WEST SUSSEX COUNTY COUNCIL CONSULTATION

TO:	Arun District Council FAO: James Cross
FROM:	WSCC - Highways Authority
DATE:	22 April 2020
LOCATION:	Aldwick Housecare Home 45 Nyewood Lane Bognor Regis PO21 2SJ
SUBJECT:	BR/86/20/PL Part change of use from a 32-bed nursing home (C2 Residential Institutions) to a 38-bedsit House in Multiple Occupation (sui generis) comprising 24 No single person & 14 No two-person bedsits along with separate shower rooms & wcs, demolition of rear conservatory & store & erection of single storey rear extension & with minor external alterations to side elevations & insertion of 4 No roof lights on rear elevation, This application is not CIL Liable.
DATE OF SITE VISIT:	n/a
RECOMMENDATION:	No Objection
S106 CONTRIBUTION TOTAL:	n/a / £ See below for breakdown.

PROPOSED SITE PLAN 1:200

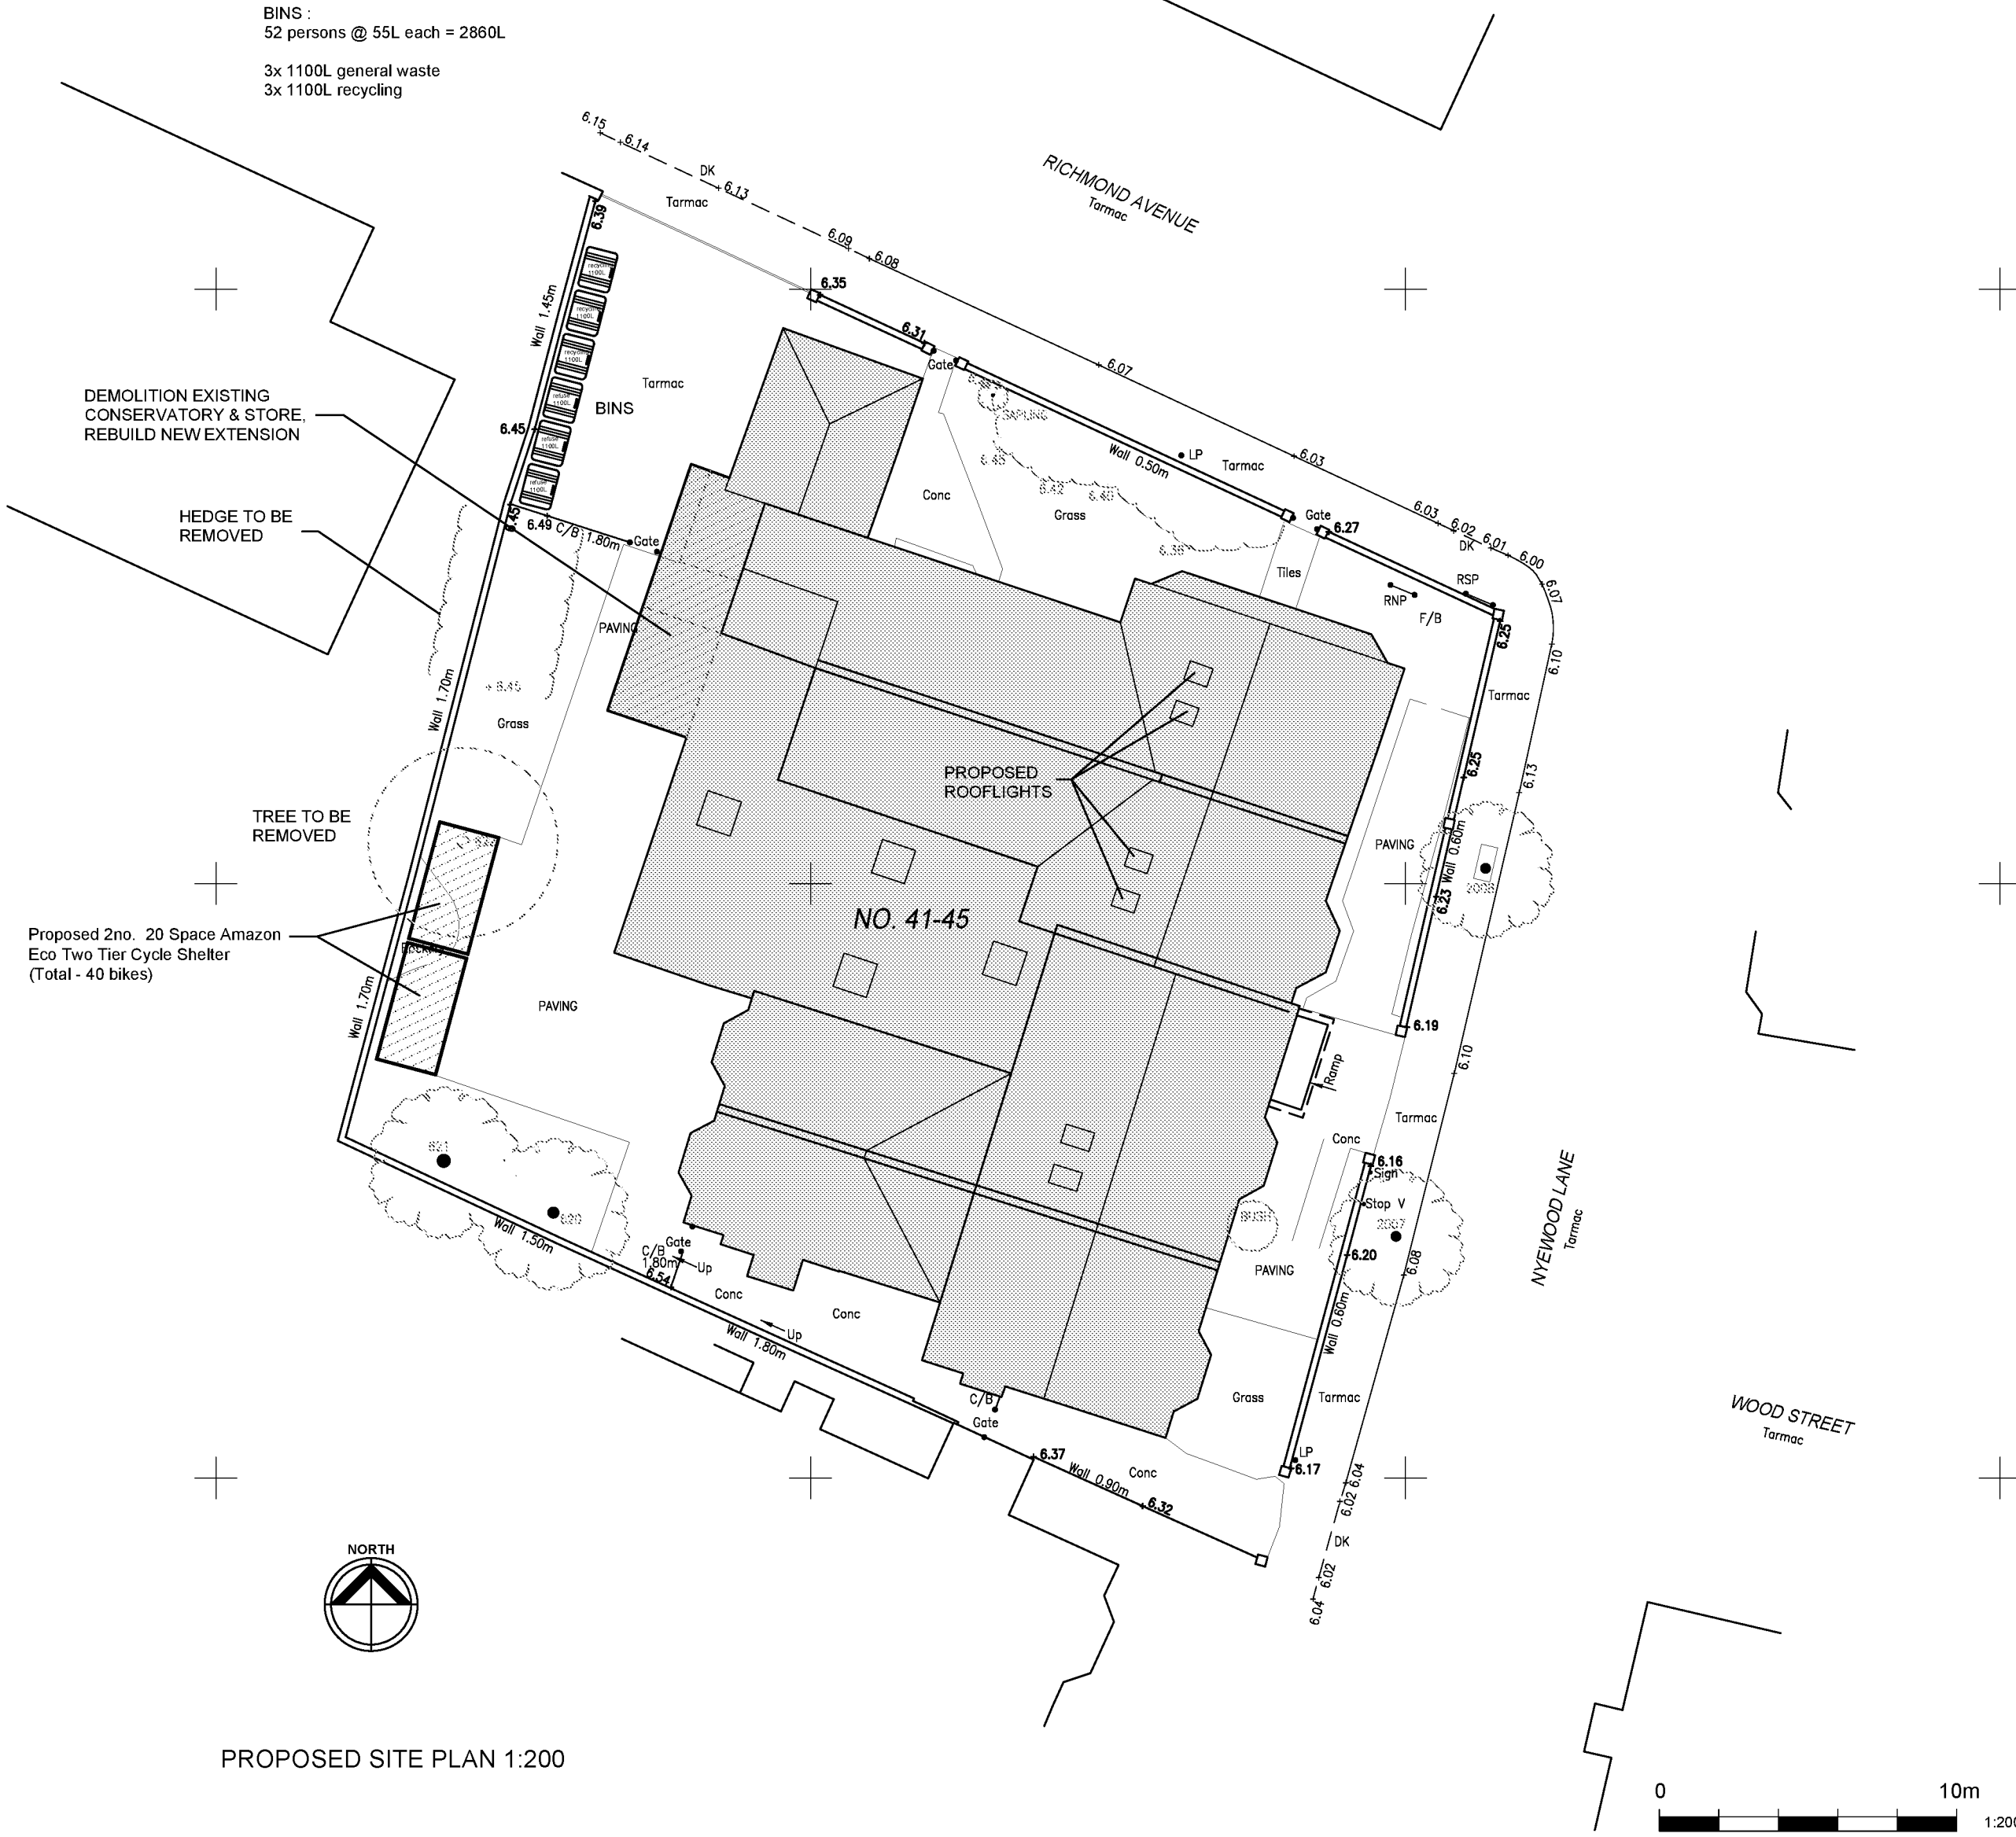
The proposals will see this area re-configured to provide a bin store area however; it is unclear if this will be kept and how this will be managed. If this is to be in use by visitors or staff this will need to be marked out to avoid it being used by other people. Please can the applicant confirm how this space will be used.
